EN010110 – Application by Medworth CHP Limited (“the Applicant”) for a Development Consent Order (“DCO”) for the Medworth Energy from Waste Combined Heat and Power Facility (“Medworth EfW CHP Facility”)

Notification of the Applicant’s intention to submit a request for changes

2. **Change 1: Minor Amendments to the Order Limits within the boundary of the existing public highway at the junction of Cromwell Road and New Bridge Lane to facilitate the carrying out of the Access Improvements to the public highway forming part of Work No.4A (the “Cromwell Road Junction Signal Scheme”)**

3. **Change 2: Minor amendments to the Order Limits within the boundary of the existing public highway at the junction of New Bridge Lane and Salters Way to install proposed drop kerbs to the existing pavement forming part of Work No.4A (the “Salters Way Junction Pavement Works”)**

**Figure 10.1iv**  
**Cromwell Road/New Bridge Lane Signal Scheme - General arrangement**

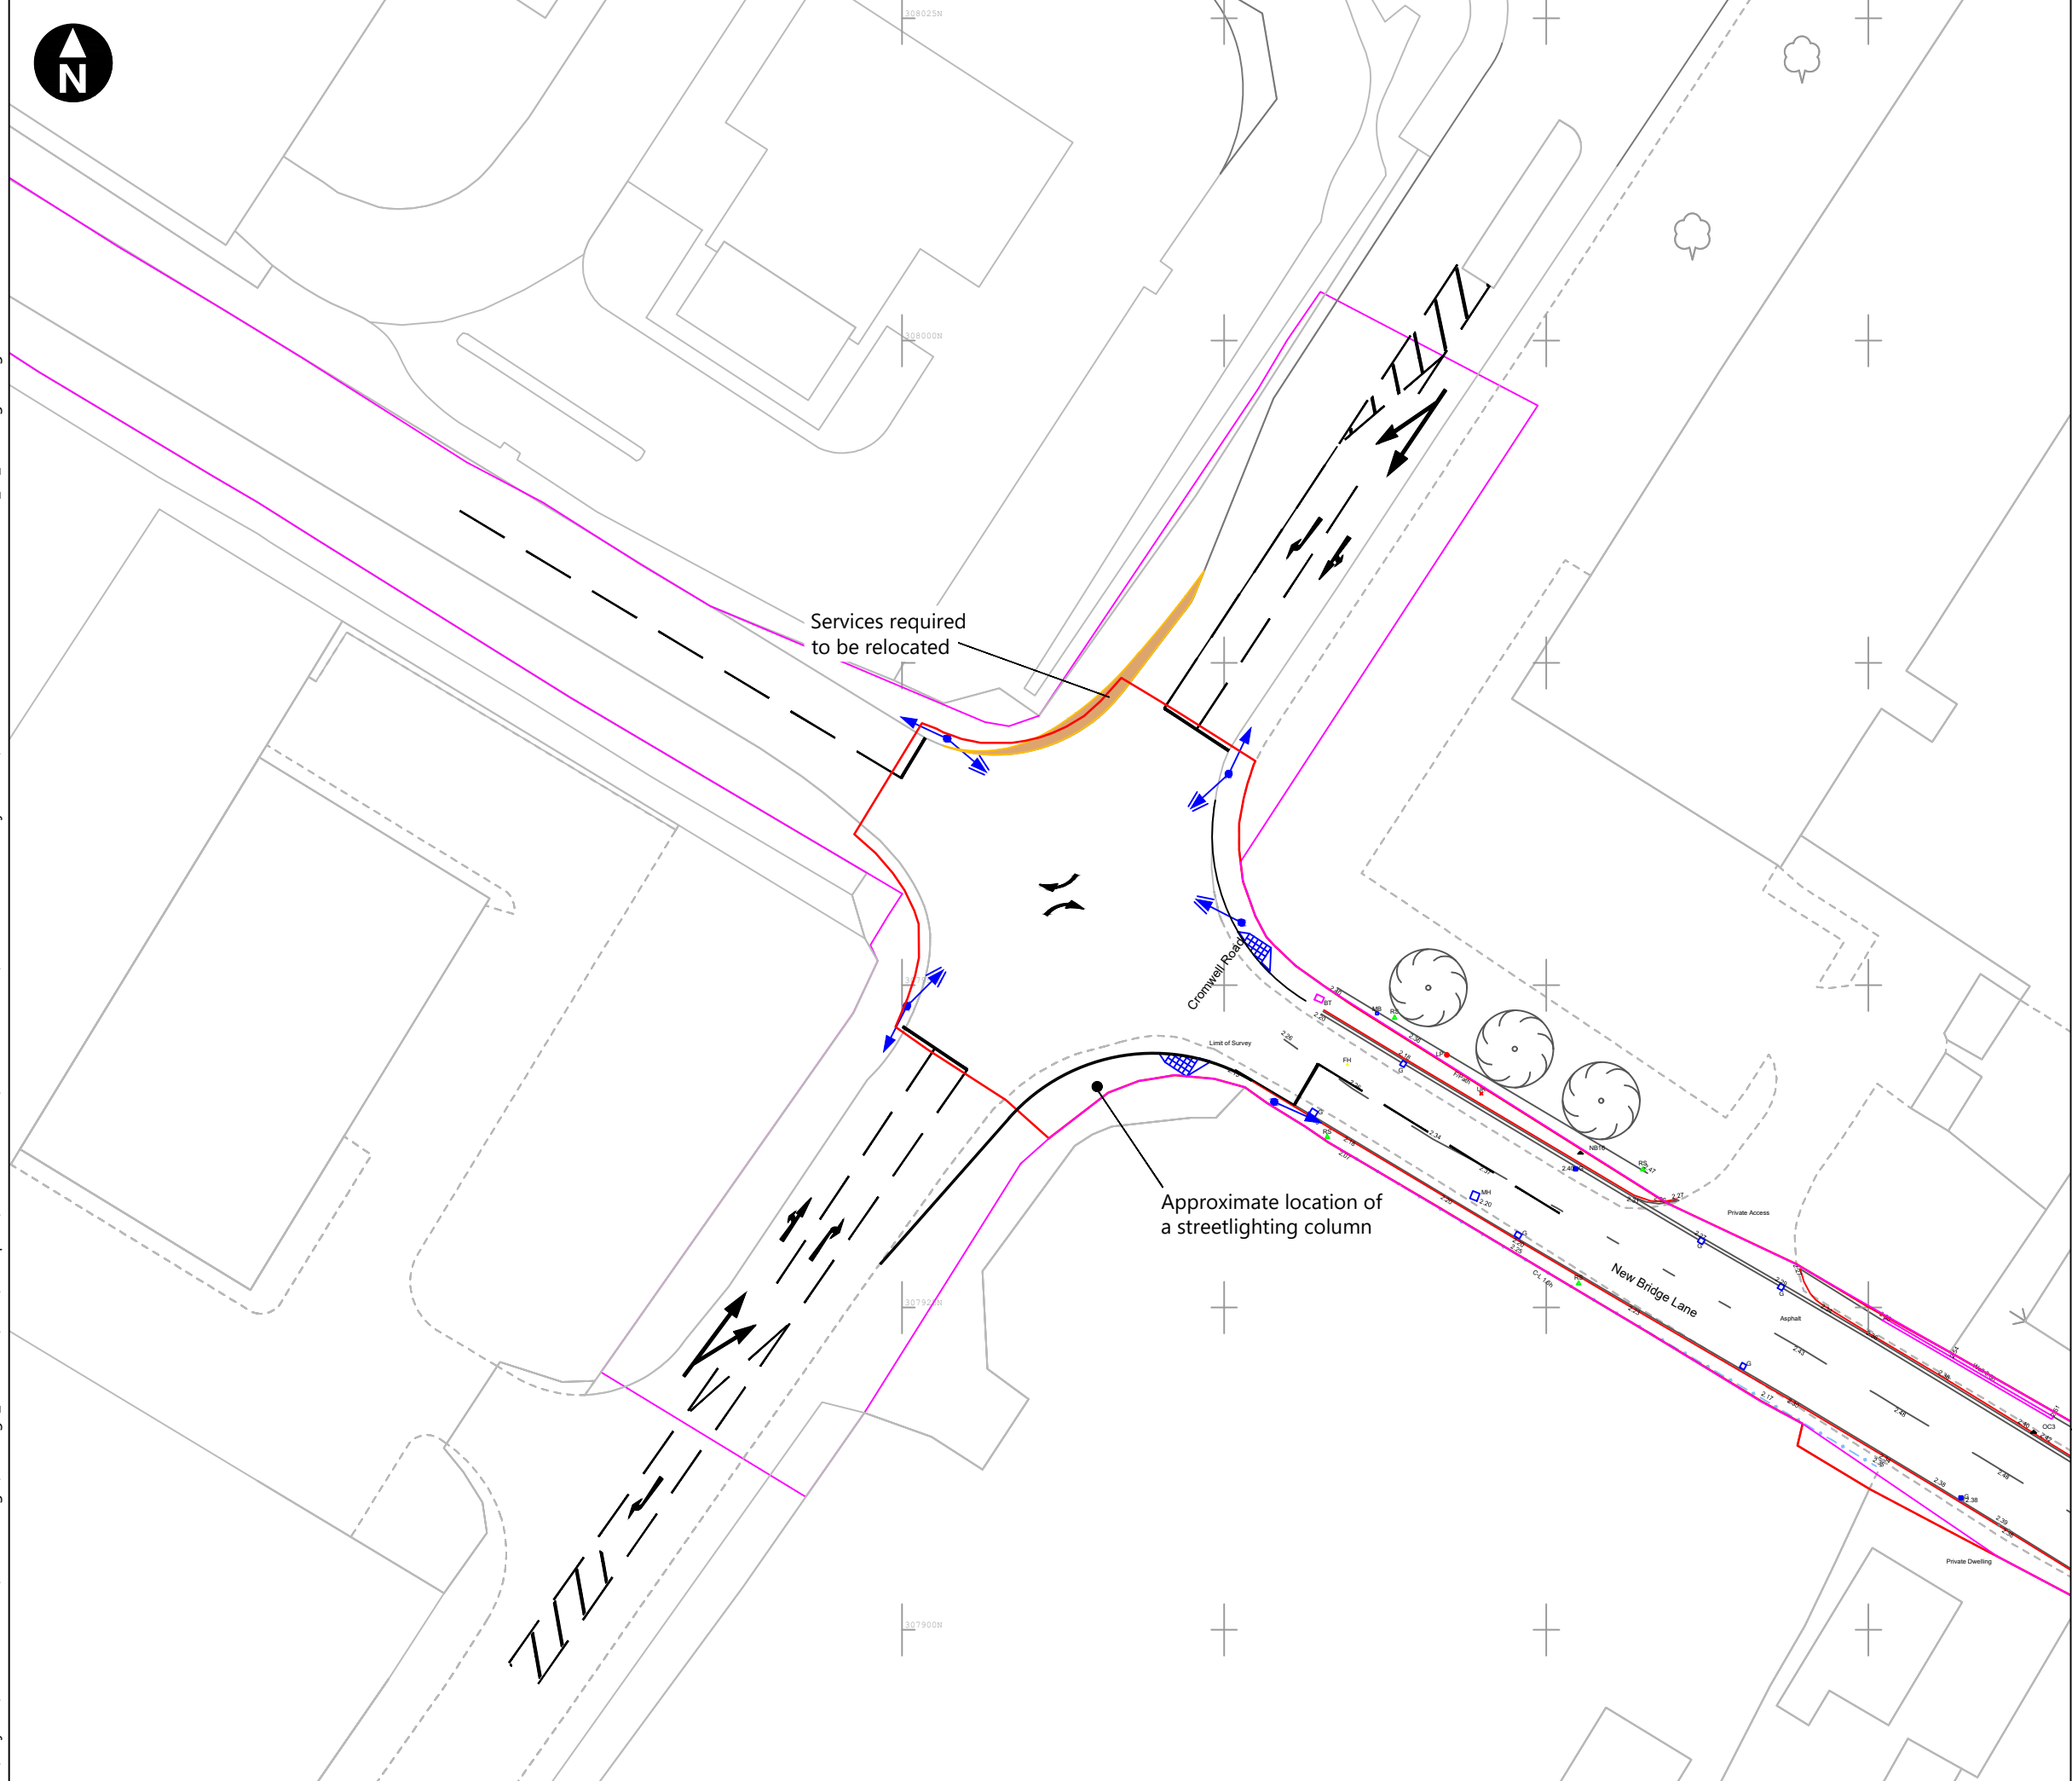
2.2 Figure 10.1iv of the Outline Construction Traffic Management Plan [REP1-010] and Figure 3.19iv of ES Chapter 3 Description of the Proposed Development - Figures 3.19 i-iv (Rev2) [REP1-009] submitted at Deadline 1 set out the general arrangement of the proposed signal scheme at the Cromwell Road and New Bridge Lane Junction. This figure identified the proposed location of the primary and secondary signal heads (traffic lights), kerb realignment and the indicative road marking scheme.

2.3 Following discussions with highway officers at CCC, the Applicant and CCC have agreed, subject to a junction assessment and stage one safety audit, a revised signal scheme (as shown on the plan attached to this letter).

2.4 In order to facilitate the revised signal scheme, the Applicant proposes to extend the Order Limits to include additional areas of the existing public highway as shown indicatively coloured orange on the plan attached to this letter. As the Applicant will only be undertaking highway works to the existing public highway pursuant to Article 11 of the draft DCO [REP3-007] in these additional areas, no compulsory acquisition powers are required over these additional areas.

2.6 The Applicant proposes to amend the drafting of Work No.4A in Schedule 1 of the draft DCO and Table 2 of Schedule 4 to the draft DCO [REP3-007] to specifically refer to the proposed signal heads for clarity.

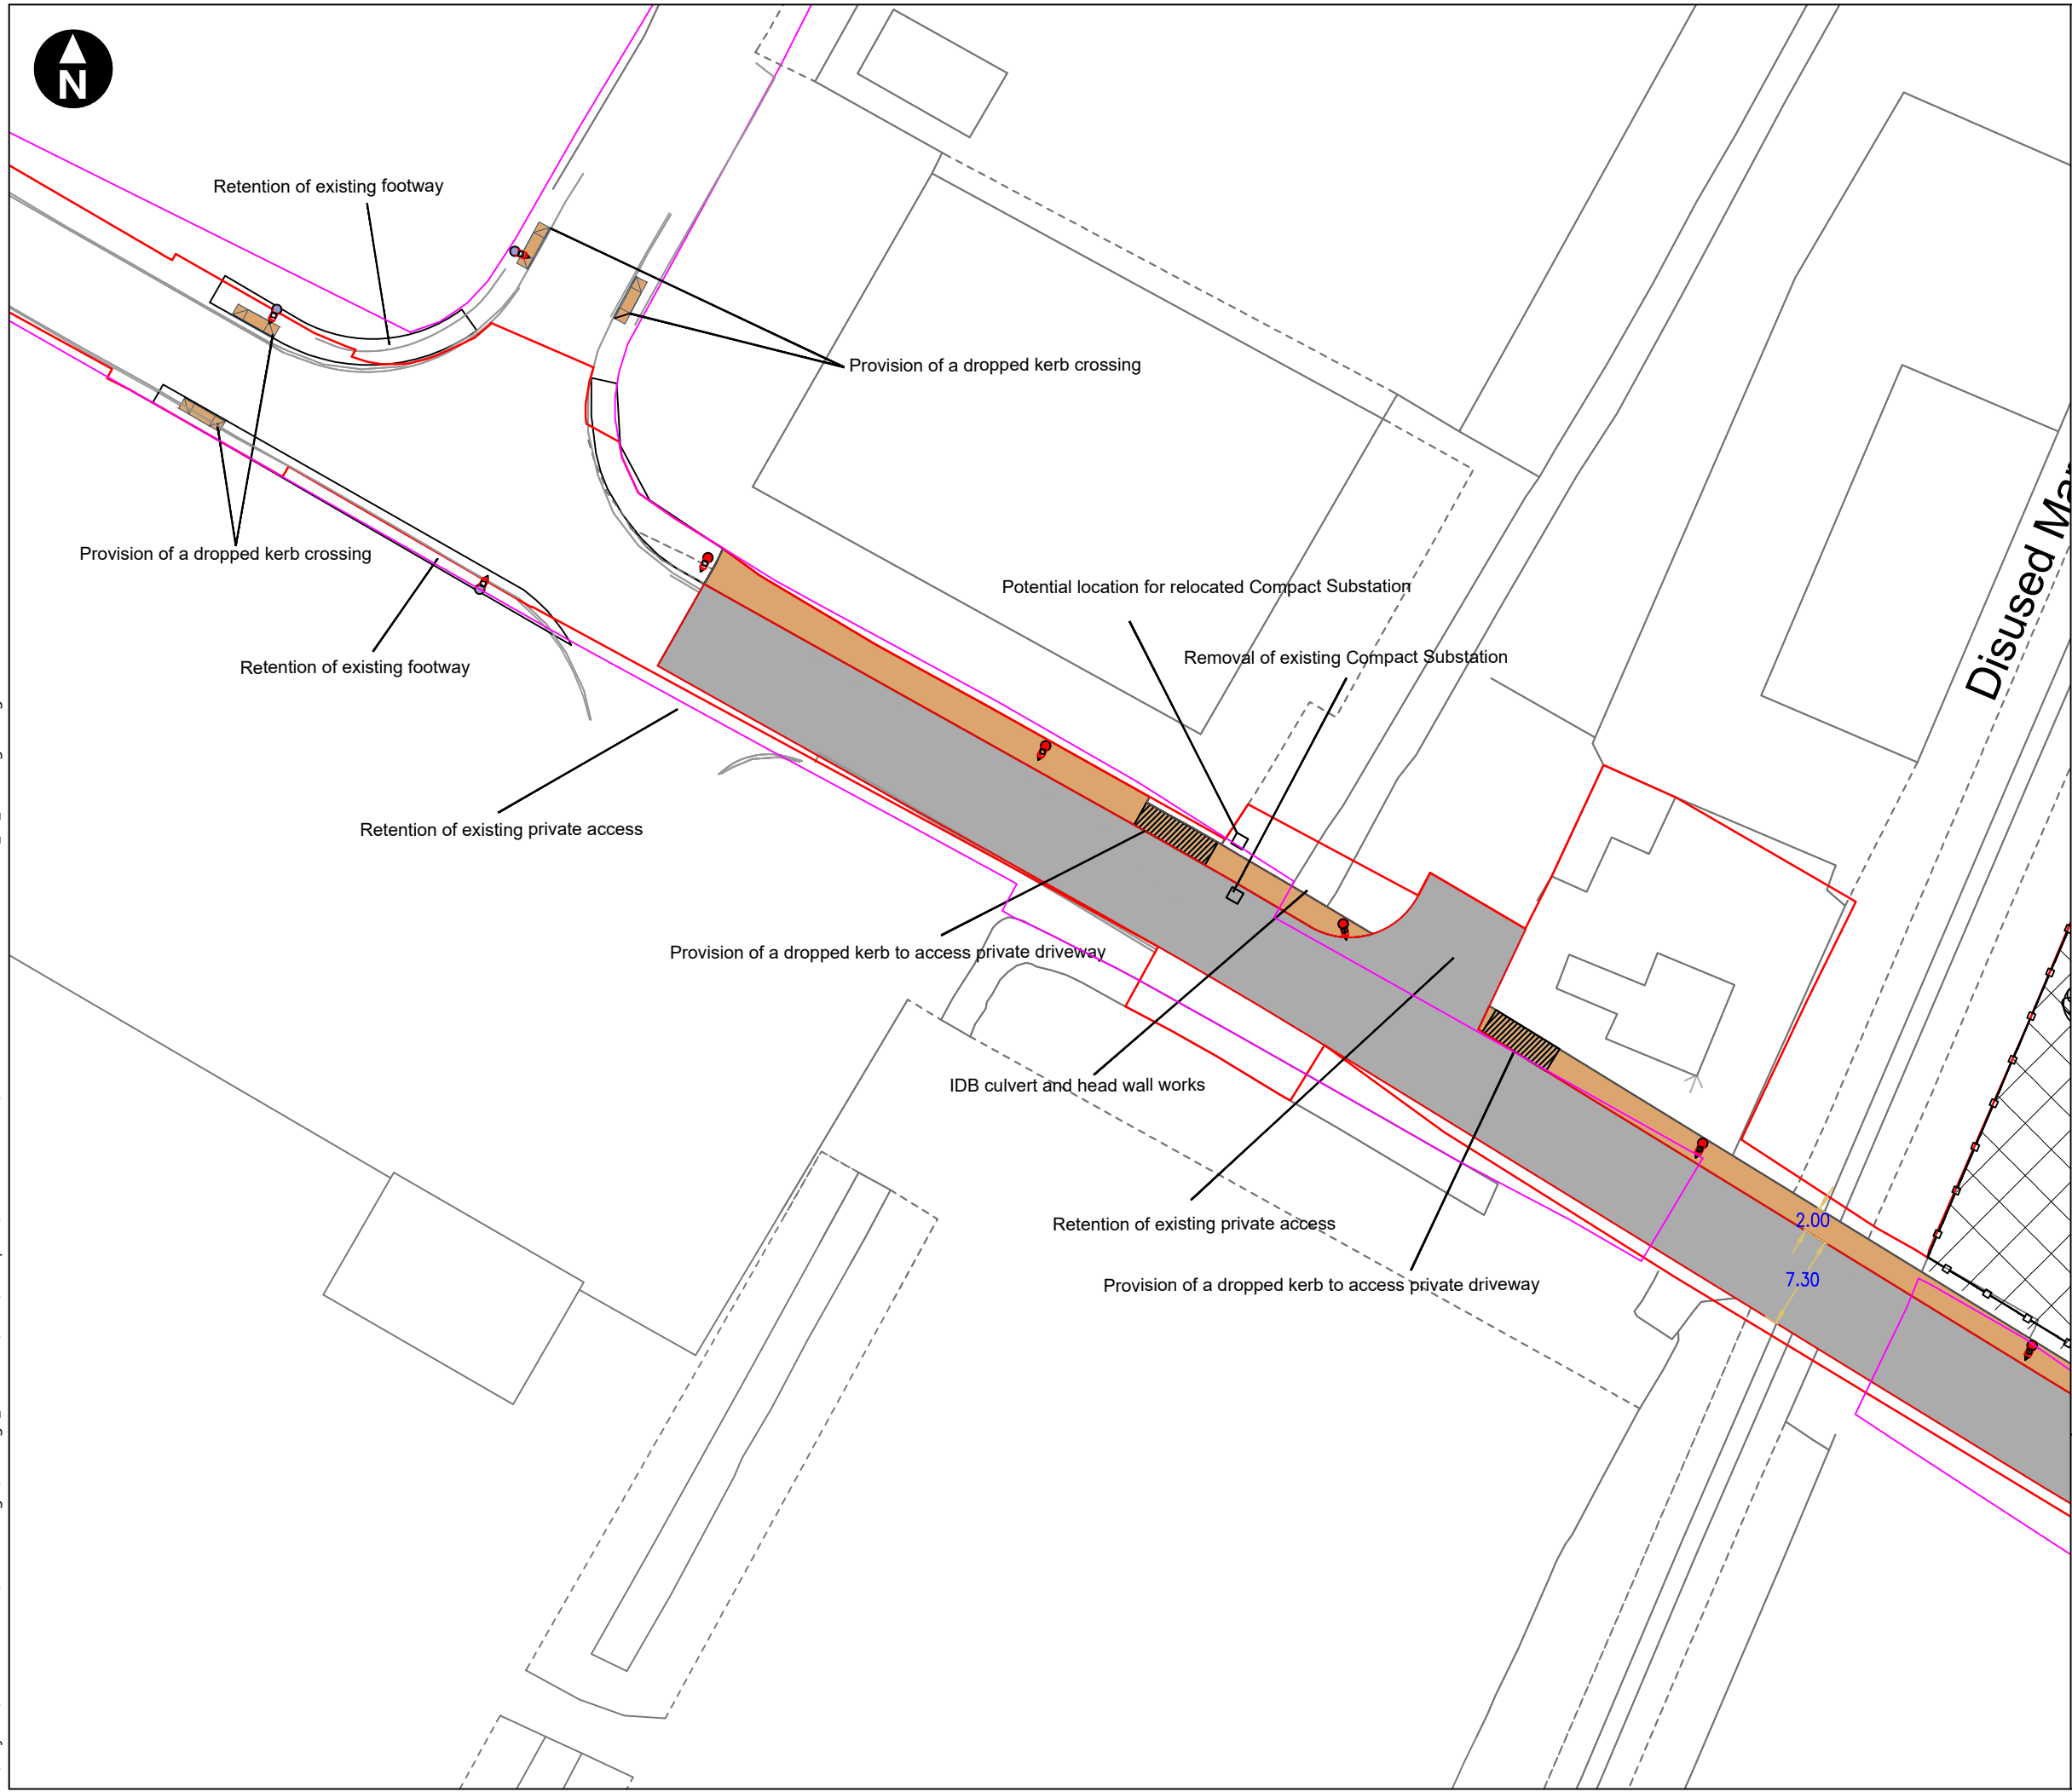
3.1 Figure 3.19ii of ES Chapter 3 Description of the Proposed Development - Figures 3.19 i-iv (Rev2) [REP1-009] submitted at Deadline 1 identified the provision of two new dropped kerbs

at the junction of New Bridge Lane and Salters Way. The Applicant notes that the proposed dropped kerbs were included to enable pedestrians to safely cross Salters Way.

- 3.2 During the technical discussions with the highway officers at CCC it was identified that the proposed dropped kerbs were located outside of the existing Order Limits.

- 3.3 In order to facilitate the construction of the proposed dropped kerbs to Salters Way Junction, the Applicant proposes to extend the Order Limits to include additional areas of the existing public highway as shown indicatively coloured orange on the plan attached to this letter. As the Applicant will only be undertaking highway works to the existing public highway pursuant to Article 11 of the draft DCO [REP3-007] in these additional areas, no compulsory acquisition powers are required over these additional areas.
